DPP Planning
Studio 015, Haylofts
St Thomas Street
Newcastle upon Tyne
NE1 4LE

Ref: KD/LF/ER/4066NE/L005

Date: 29th March 2023

Application for a Section 73 minor material amendment application in respect to conditions 2 (Approved Plans) and 5 (EV Charging Details) of planning application reference 21/03106/FUL to allow for minor external amendments, approval of EV charging point details and an amendment to the EV charging strategy of the approved Co-operative Food store at Mace Convenience Store, Townfoot, Rothbury, Morpeth, Northumberland, NE65 7SL.

TITLE
Proposed Site Plan

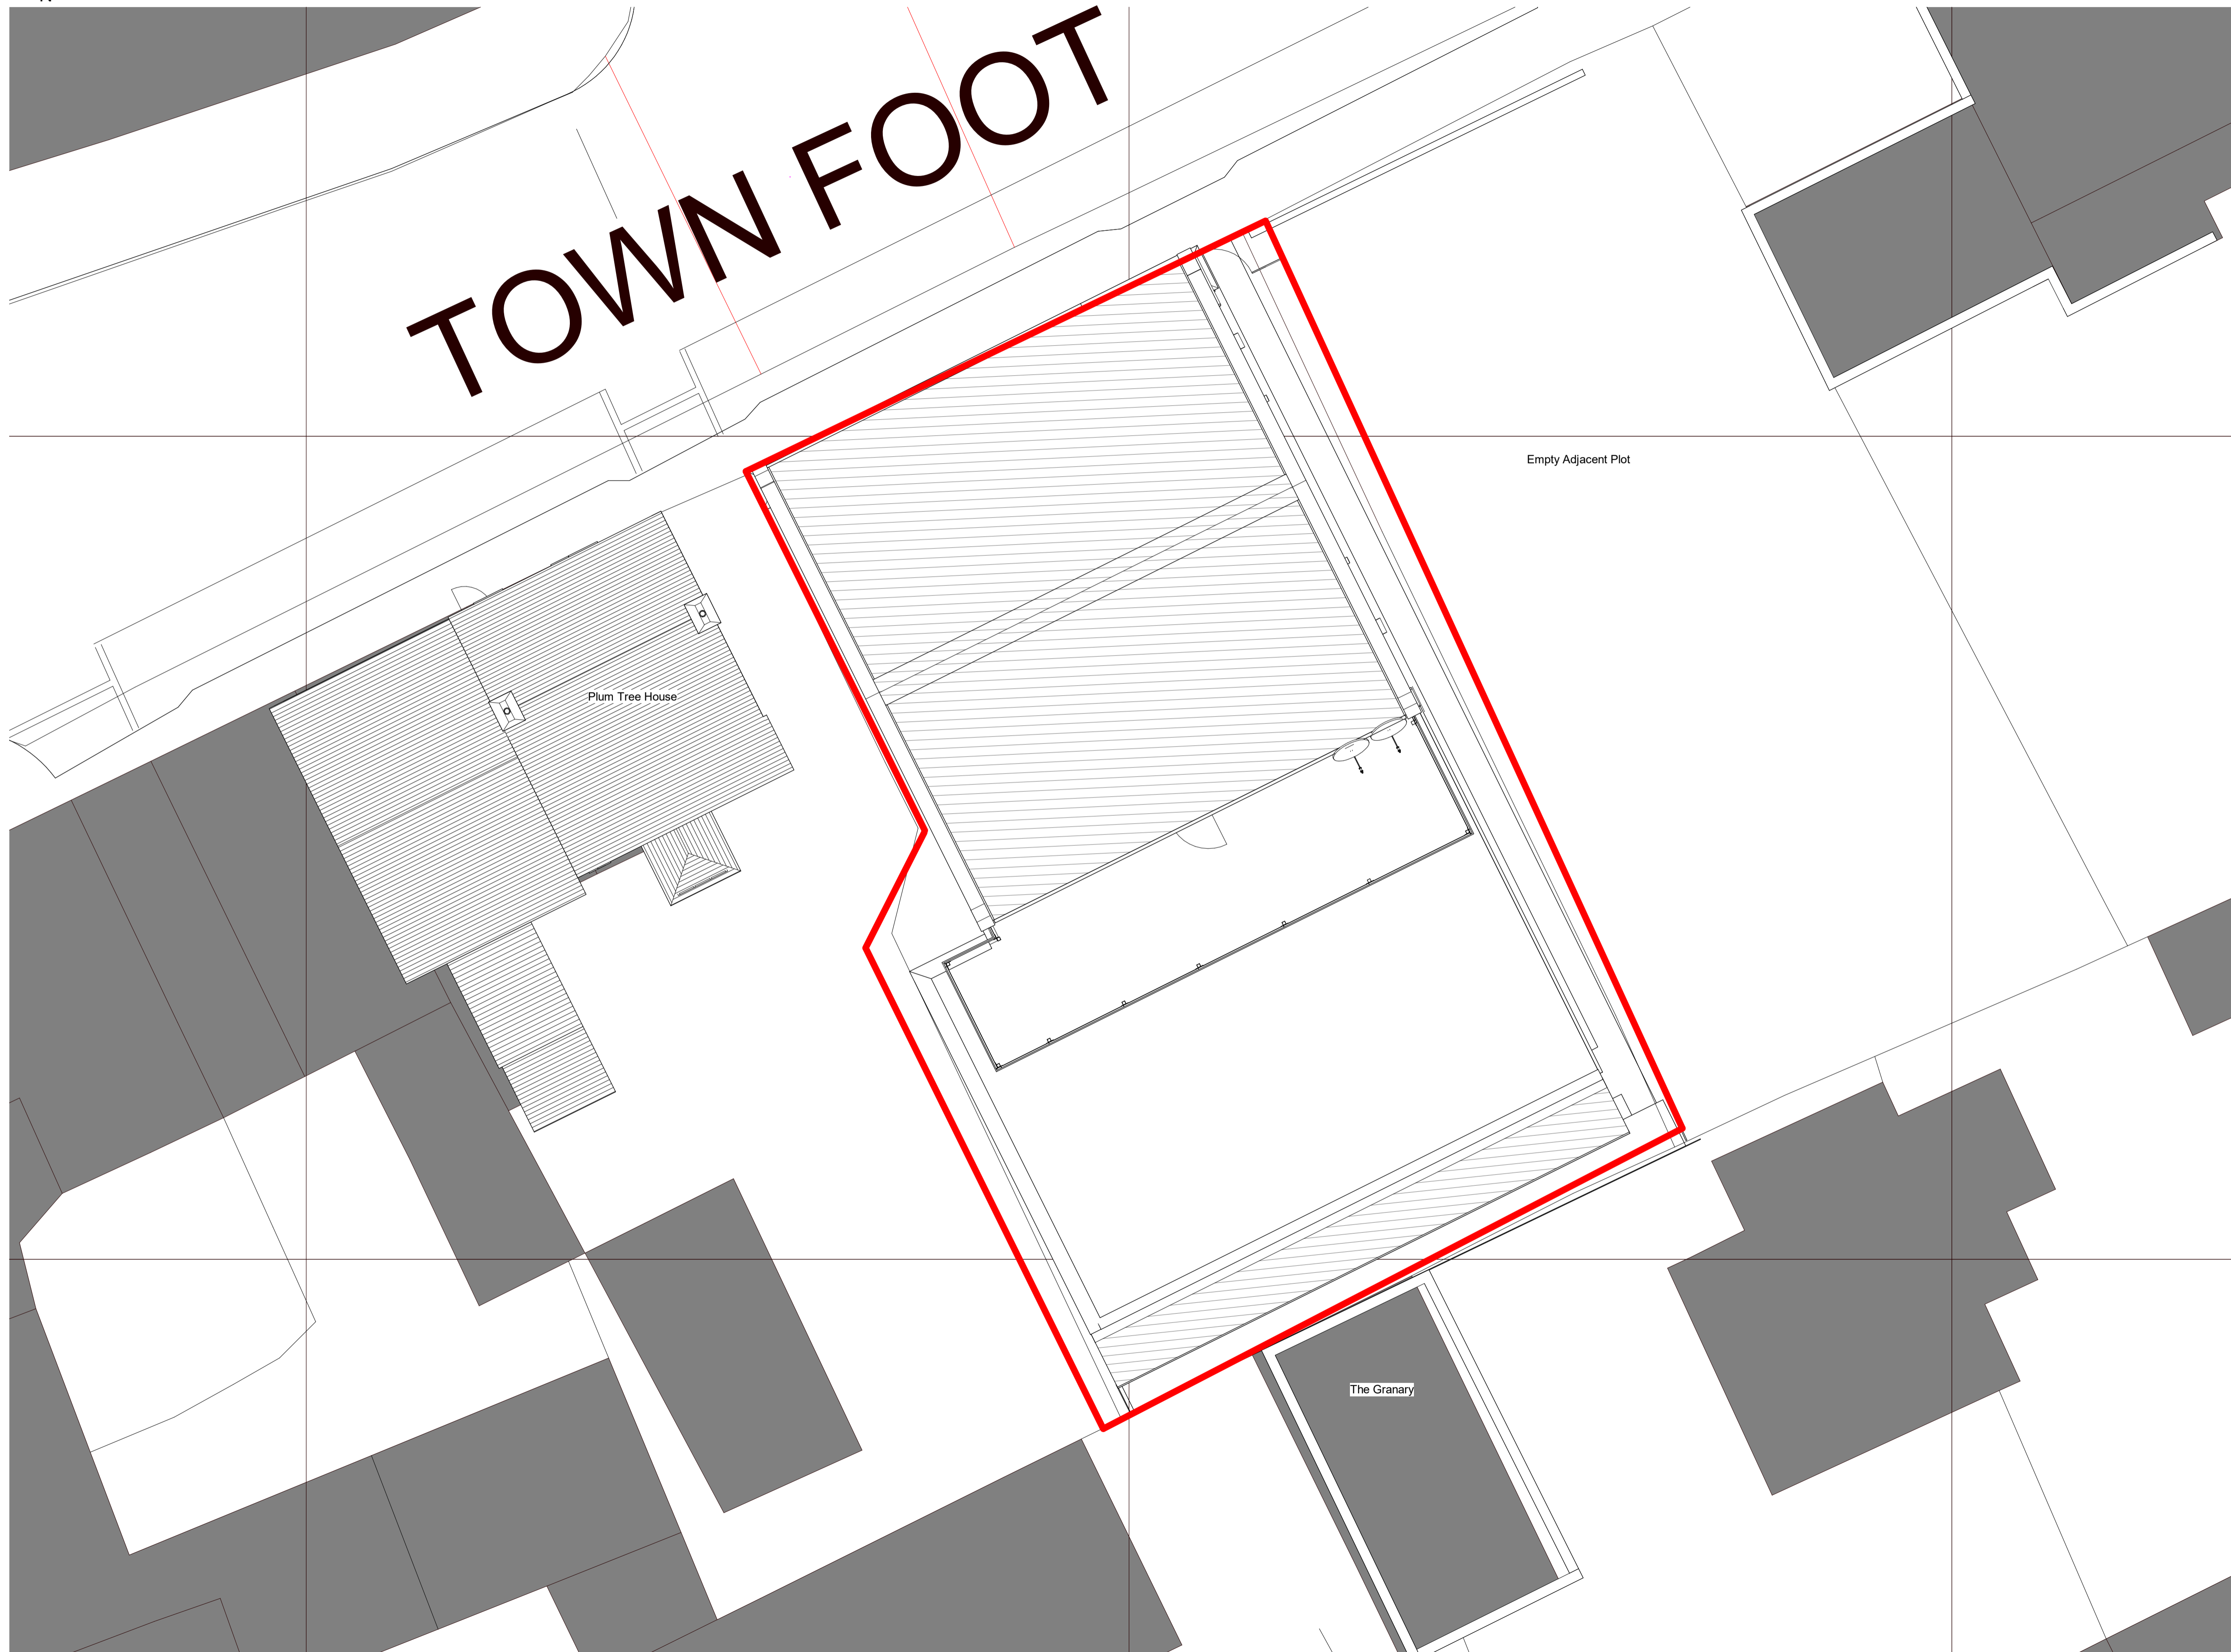
Although largely dealt with under condition 5 as referred to below, it is proposed to relocate the EV charging points originally proposed outside of the shop to the opposite side of Townfoot. The Proposed Site Plan and Highways Works Plan have been updated accordingly and we have submitted an additional EV Charging Point Detail Plan and supporting brochure for approval.

As referred to above, it is proposed to relocate the EV charging points originally proposed outside of the shop to the opposite side of Townfoot as this will provide additional highways relief. The previous proposals would not allow the provision of standard bays outside of the shop, which would dilute the mix of the on-street parking arrangement to an unacceptable level. Three parking spaces are to be relocated to the front of the store from the west of the site where the new bus stop is to be located. The accessible parking bay has also been reconfigured to meet the relevant standards.

SPECIFICATION NUMBER - 11S019-S01

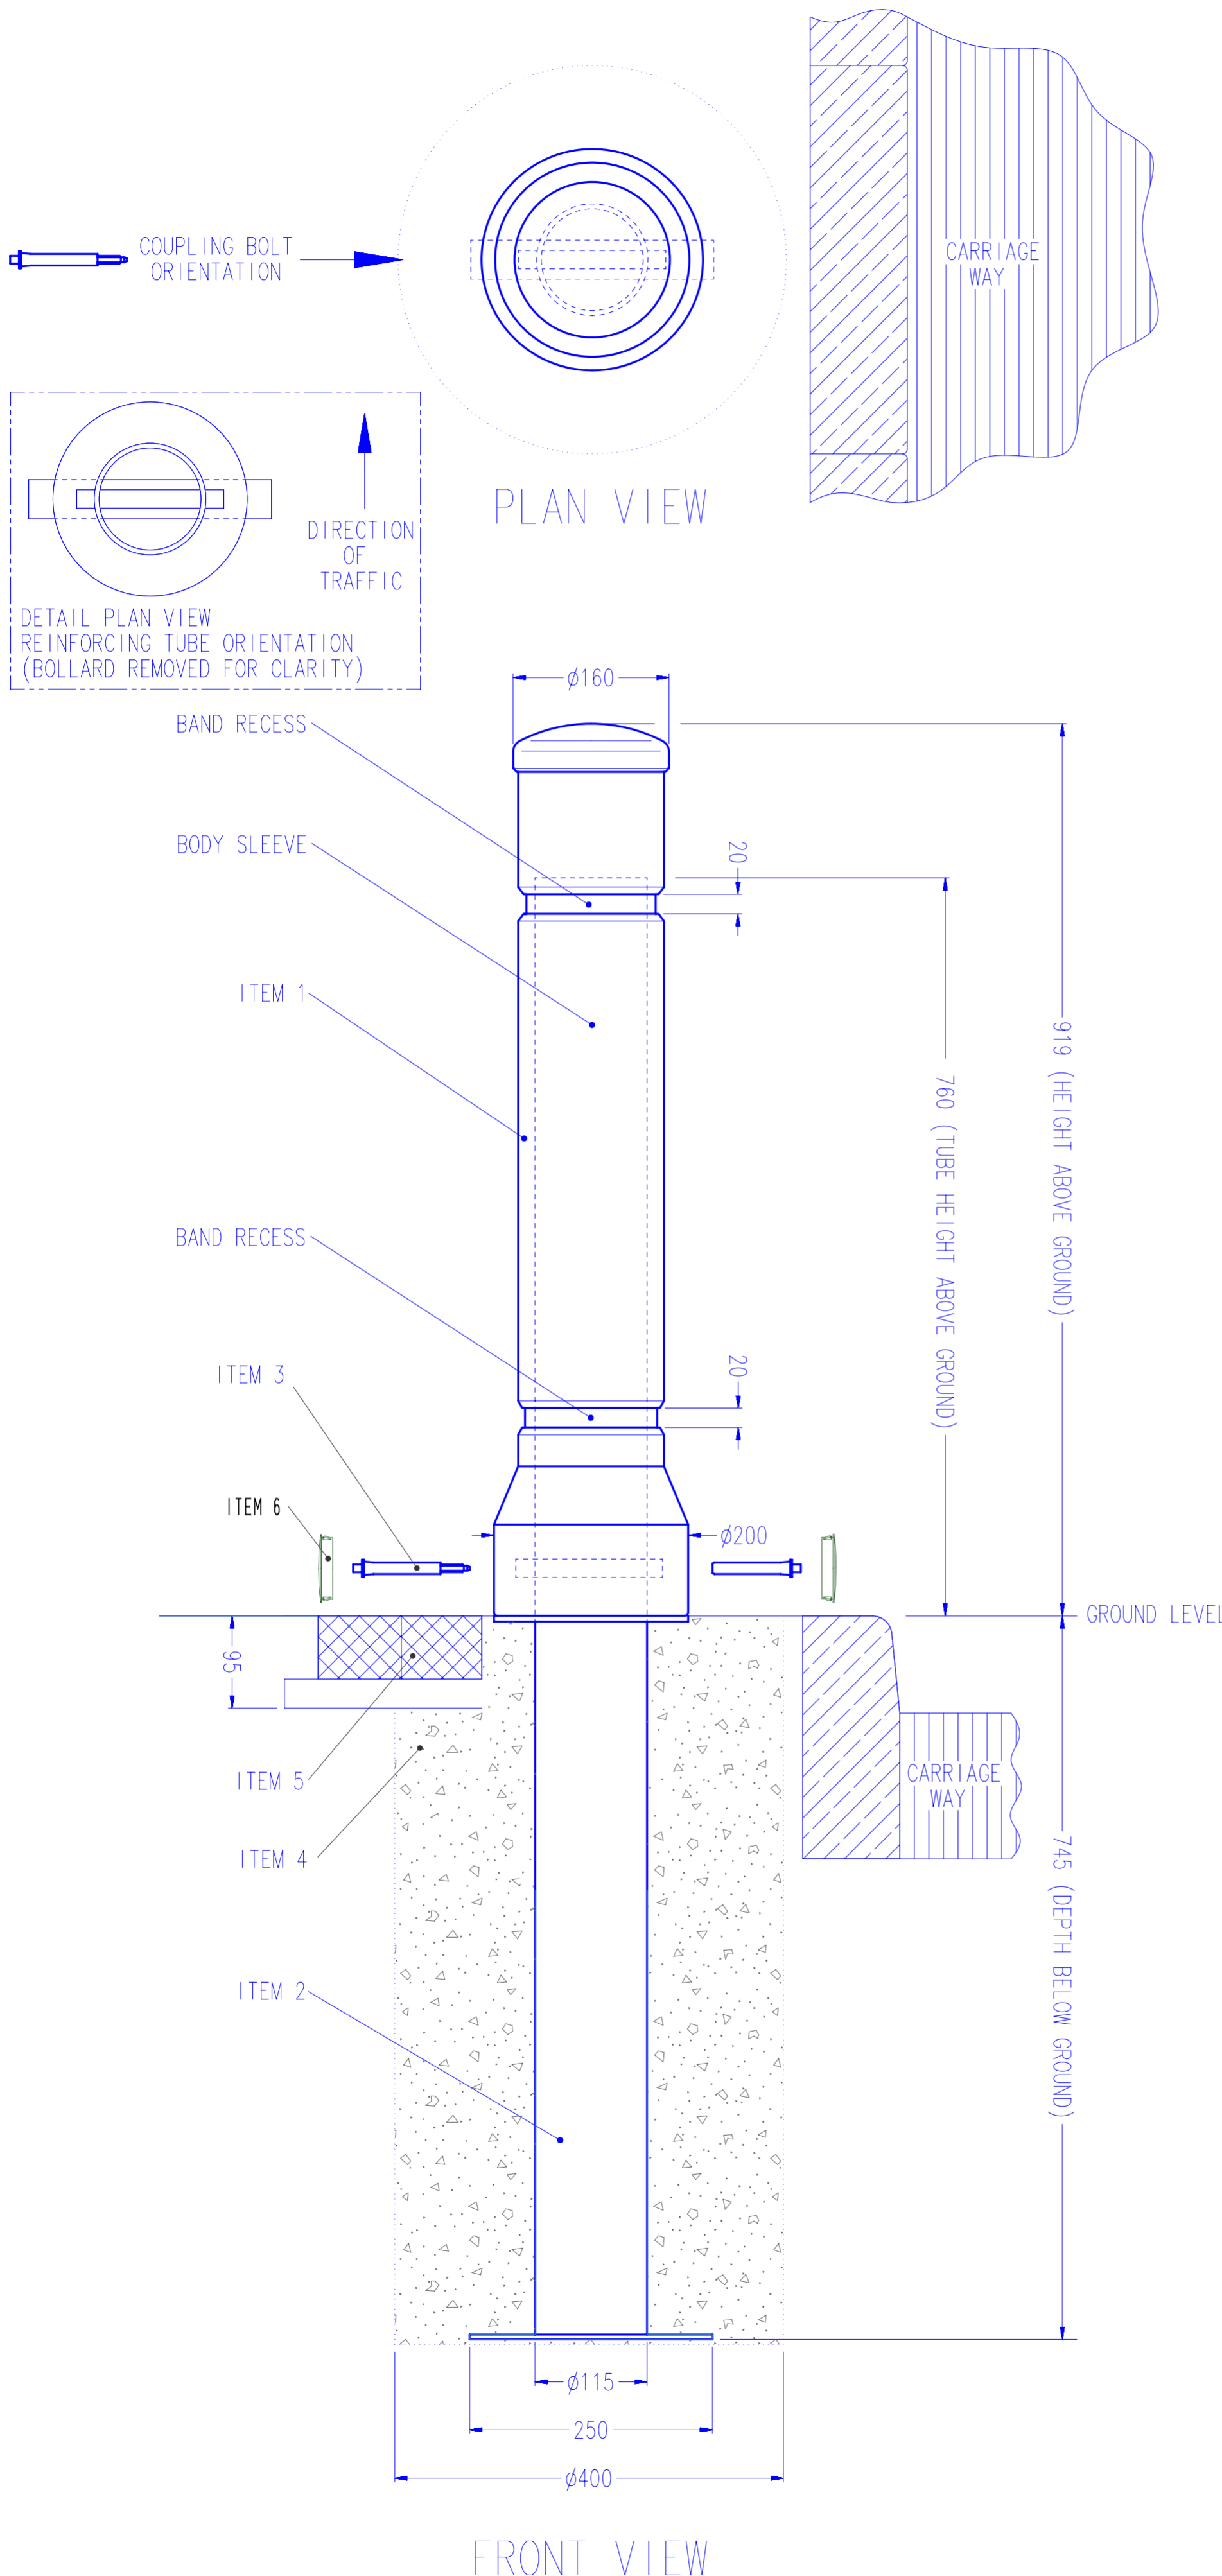
The updated Level 0 GA Plan, North & East Elevations and Shop Front Detail Elevation also account for new bollards which are required to protect the ATM machine. The submitted bollards details sheet (ref: 11S019-S01-ISSUE-08) provides further information on the specification of the bollards.
